PLANNING WORKSHEET 11 – DELEGATED / PCG REPORT - GENERAL

Application Ref.	22/00763/HSE	
Site Address	Greenacres Linecroft Lane Walkeringham Doncaster South Yorkshire	
Proposal	Single Storey Rear Extension	
Case Officer	Daniel Galpin	
Decision Level	Delegated	
Recommendation	Grant	
Reason(s) for PCG referral		
PCG Sign off and date		
	Signature	Date
Case Officer	<i>D. Galpin</i>	12 th July 2022
Authorised signing Manager	<i>J. Through</i>	18 th July 2022

REAR ELEVATION

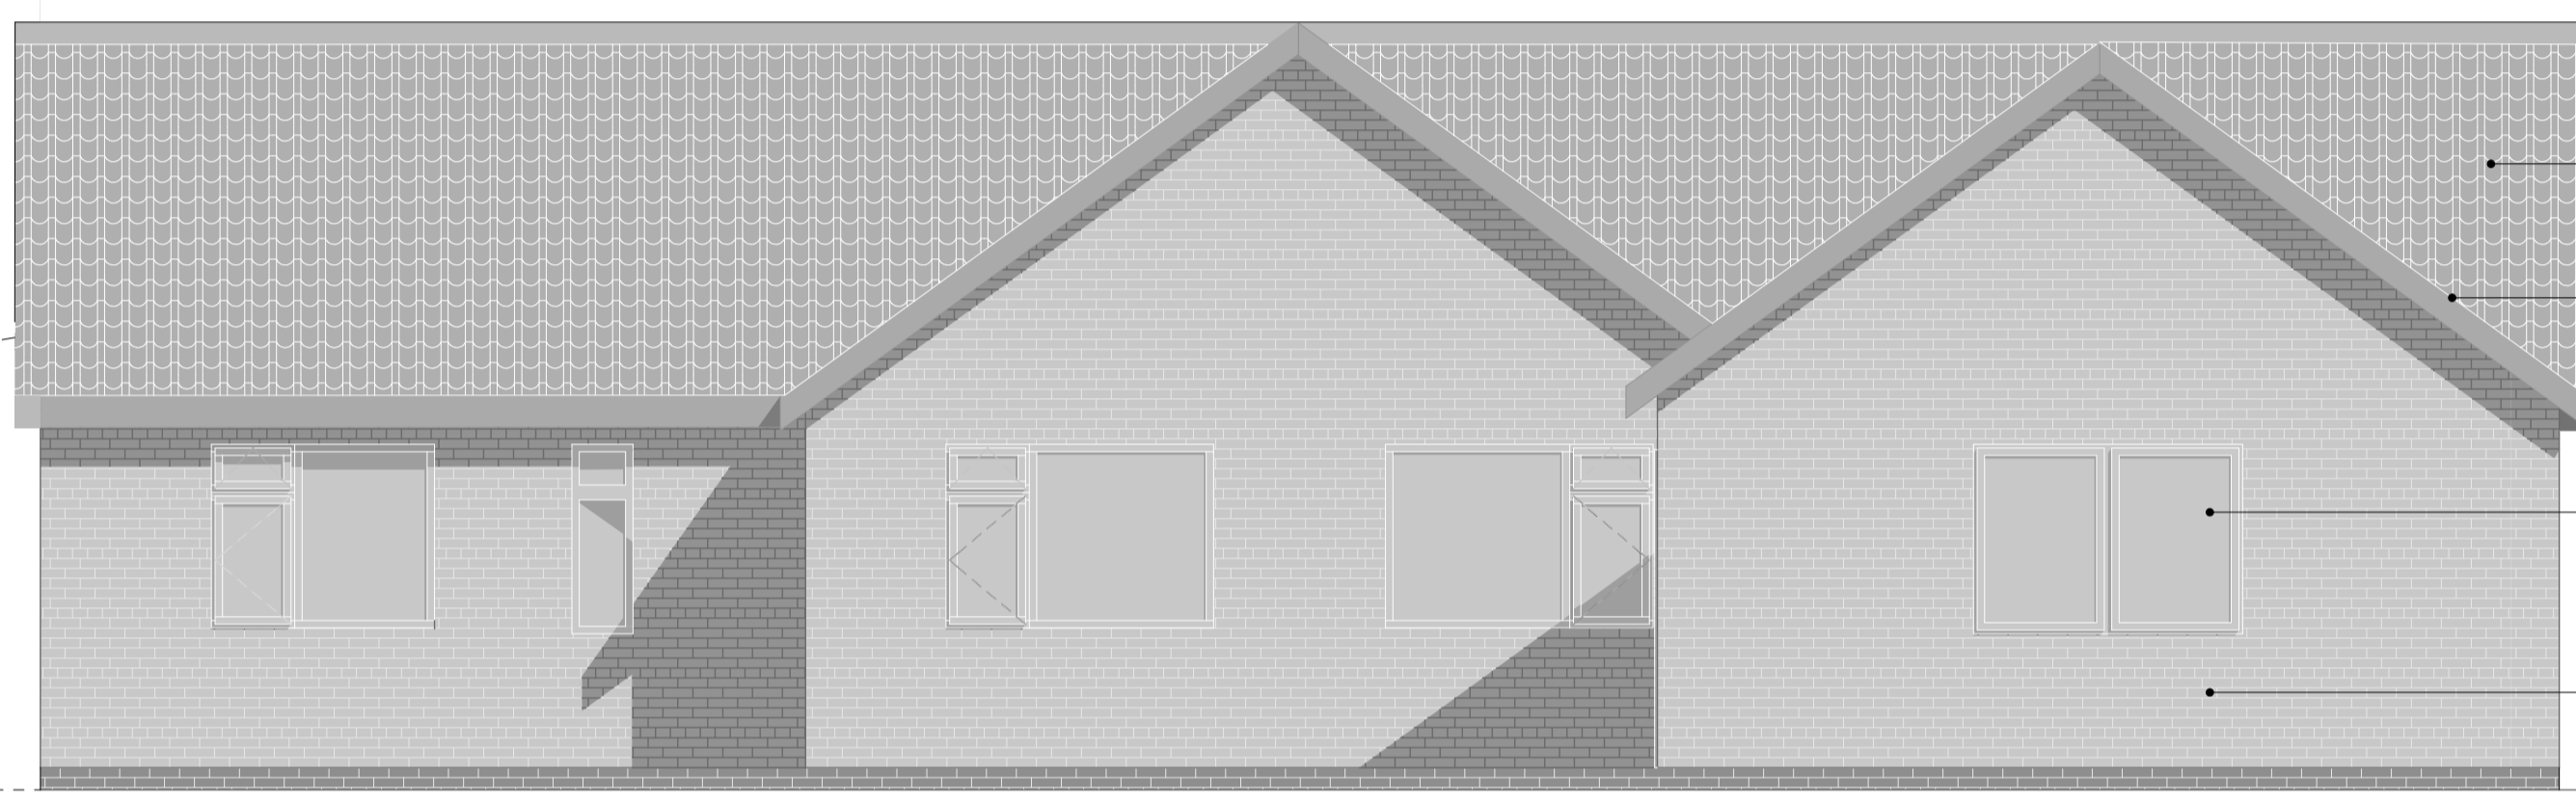
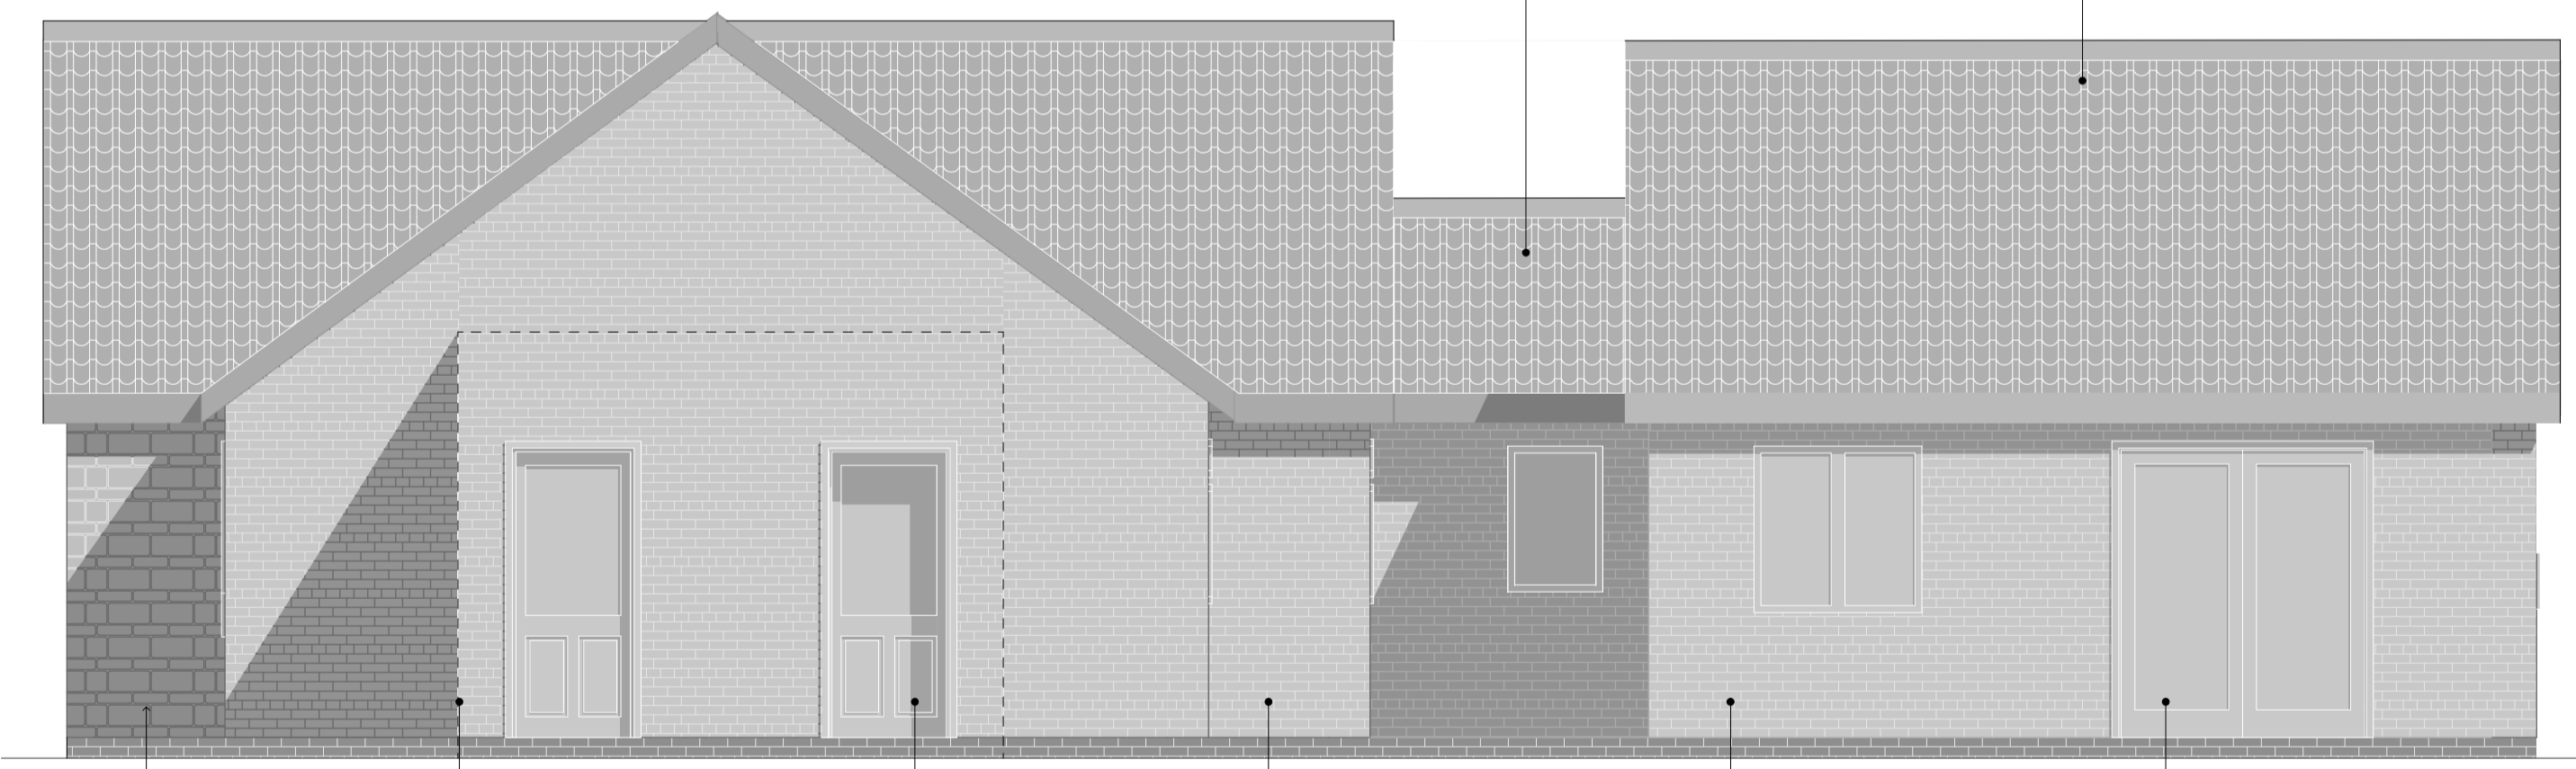
There are some issues with the design of the dwelling such the new gable slightly overlapping the existing projecting gable when viewed directly from the rear elevation. However, this effect is unlikely to be easily viewed from public vantage points as the rear elevation is not readily visible from the road, especially in the context of the new rear extension which will screen the rear elevation. The drop in ridge height for part of the rear extension will serve to give the extension a slightly fractured appearance but the overall impact on visual amenity is not expected to be significant. The dwelling is also partially screened by a hedgerow; although this is only about one third of the height of the dwelling this does serve to slightly mitigate the prominence of the dwelling in the context of open countryside.

These issues do serve to slightly detract from the appearance of the dwelling, but the overall proposal does retain the existing character of the dwelling sufficiently that it is unlikely that such an objection could be maintained as a reason for refusal. As such, the proposed development would not be an unacceptable visual intrusion into the surrounding landscape character.
